Our Ref: KFOR 15/138

Kings Forest Major Project Approval No. 08-0194 (MOD 3)
Proposed Service Station & Food and Drink Premises Within Precinct 1

On behalf of the proponents (Project 28 Pty Ltd) we provide the following response to Tweed Shire Council's email submission dated 20 November 2015. Issues raised by Council are reproduced in **bold** text.

Scale	Date	Job Number	
1:2500@A3	NOV 2015	738.12	
Drawn	Stage	Drawing No.	Issue
PN	DA	0000	E

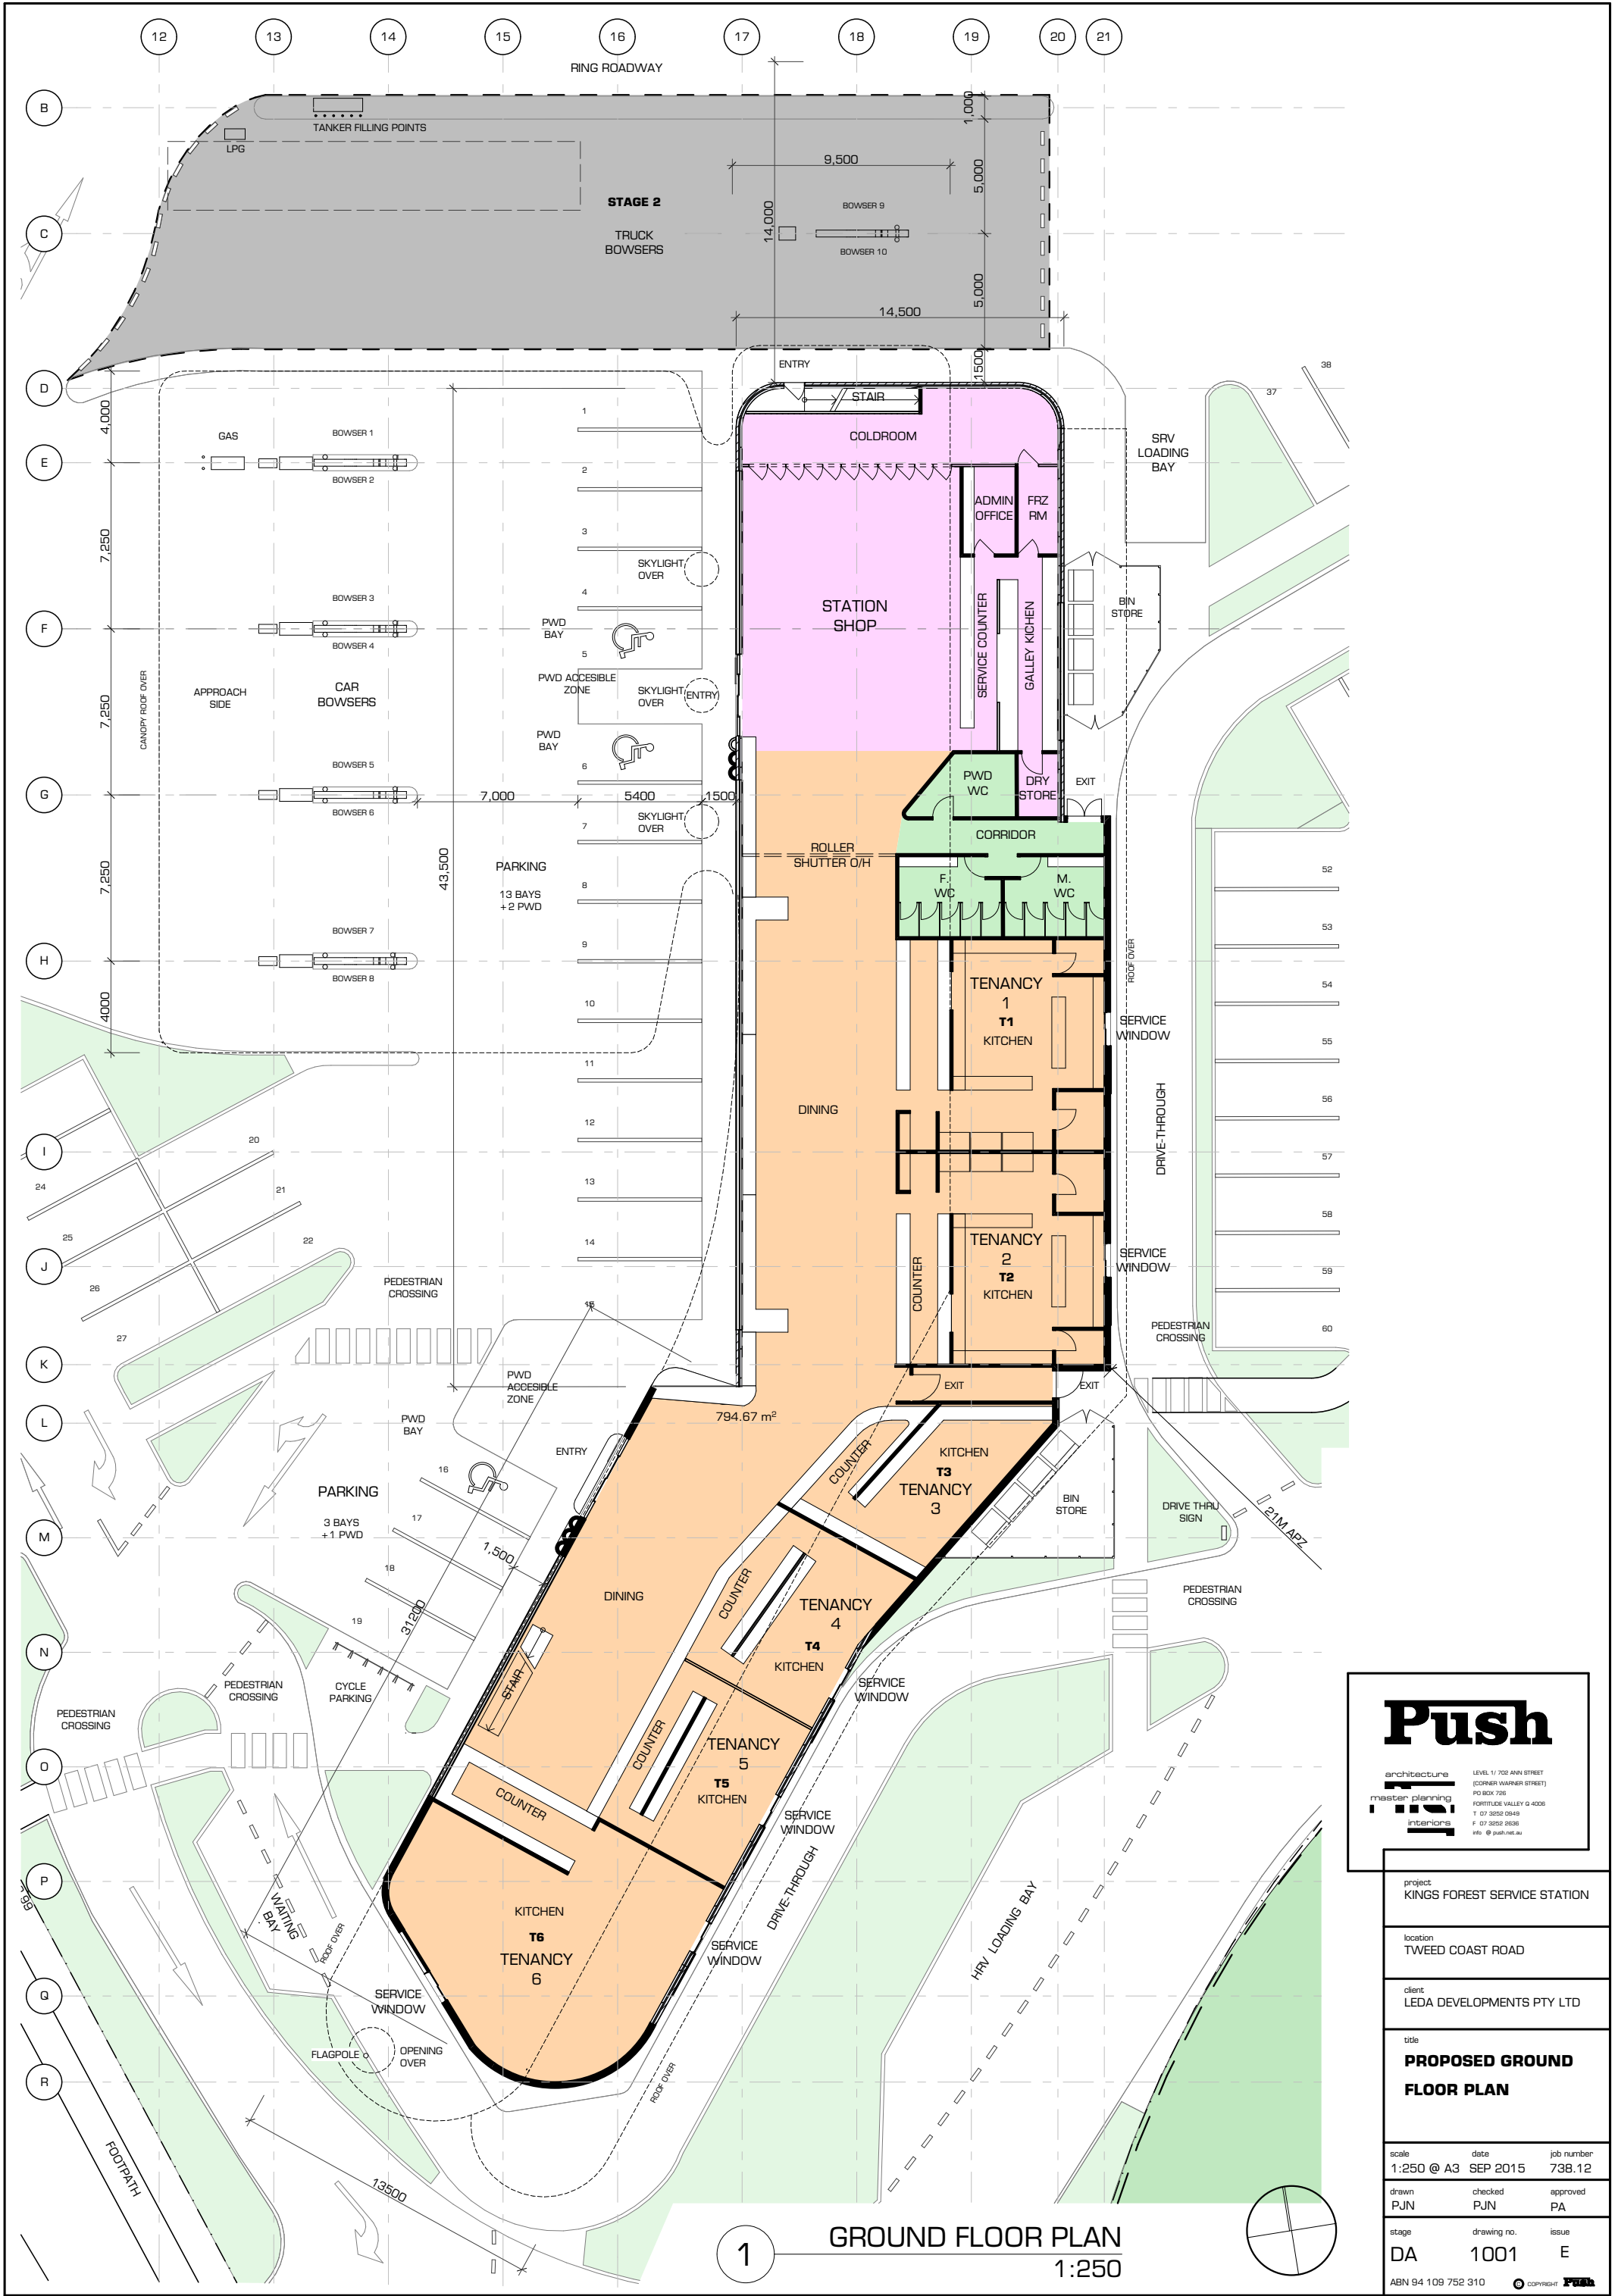
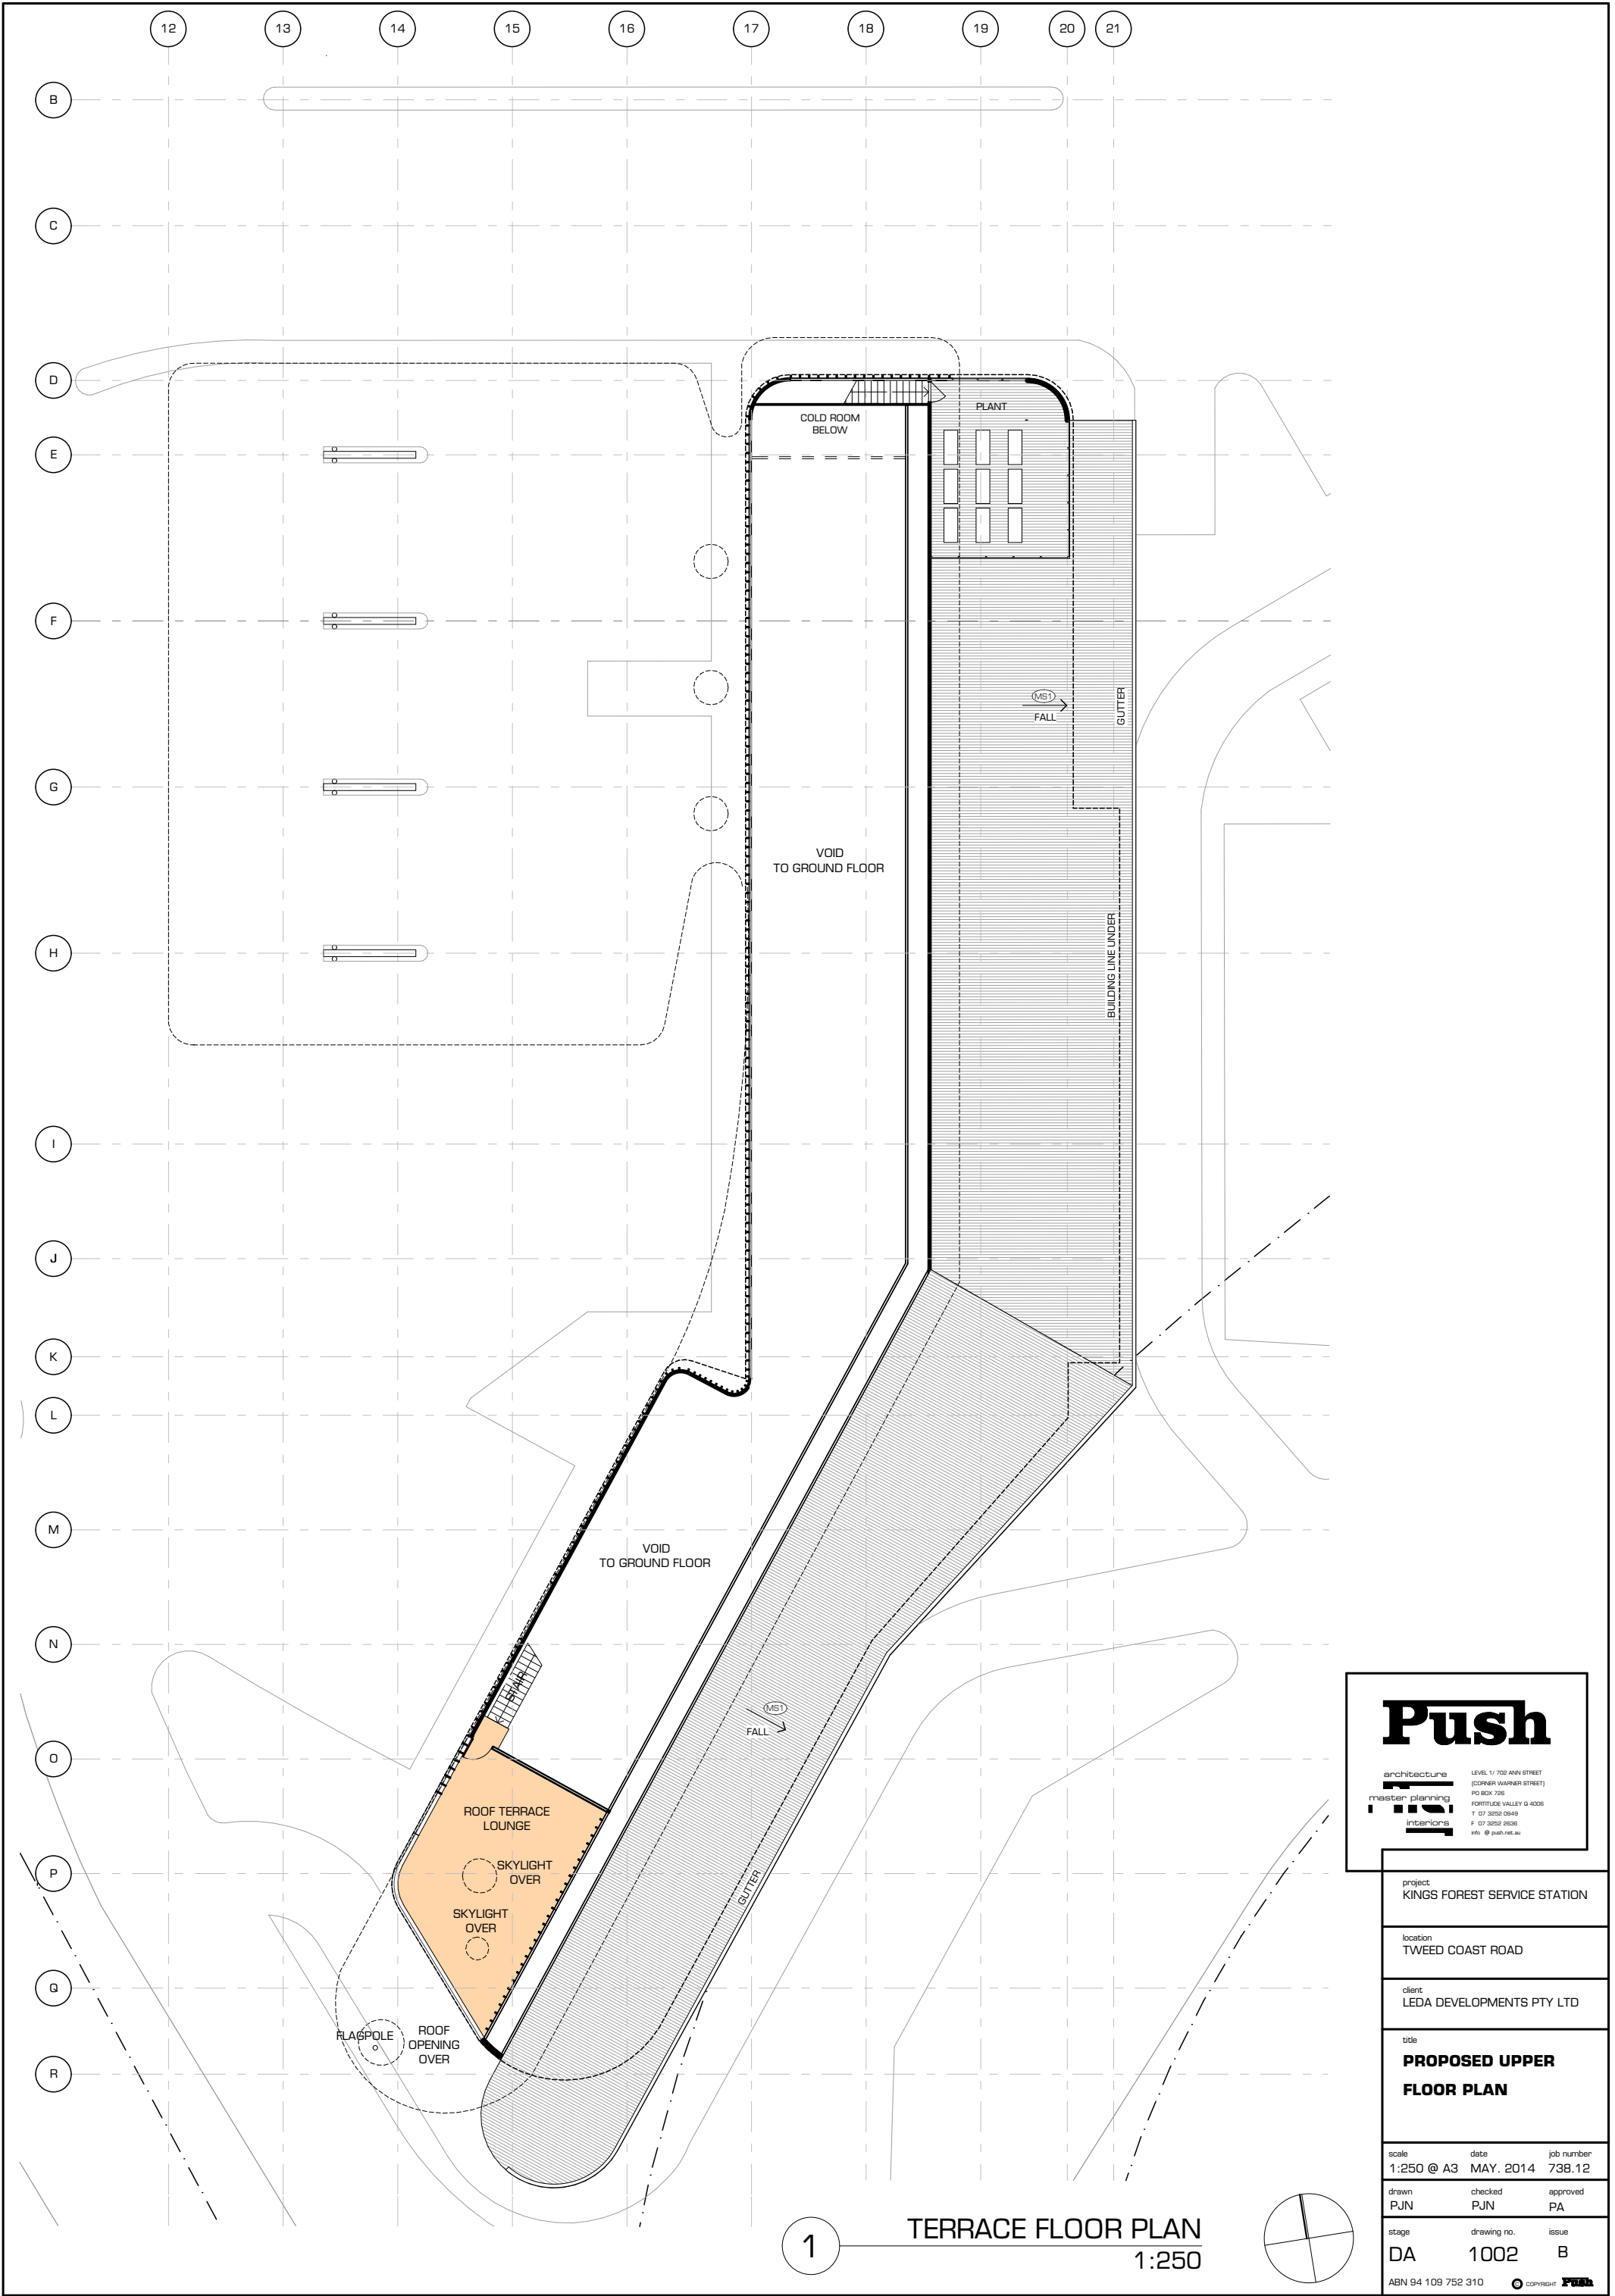
"The outer 20m of the 50m ecological buffer appears to be nominated for car parking and bushfire asset protection which appears contrary to the approved Preferred Project Report which locates these uses outside of the ecological buffer. As a consequence of this the proposed koala exclusion fencing is now located 20m inside the ecological buffer contrary to PAC condition 46 which specifically requires such fencing to be located on the outer edge of the 50m buffer. The application provides no justification for this, incorrectly stating that: This proposed modification maintains the approved strategies of the Koala Plan of Management for Kings Forest excluding Koalas from the development footprint area and positions boundary fencing in the previously approved locations.(See p 15 of Modification Report)."

We **attach** the Koala Exclusion Fencing Location Plan, (Planit Consulting, 05/15) which shows the fencing on the outer edge of the 50m ecological buffer.

We also **attach** amended Architectural Drawings (Push, 12 Sheets) showing the fence on the outer edge of the 50m ecological buffer. The amended plans are consistent with Condition 46(4) of the Project Approval.
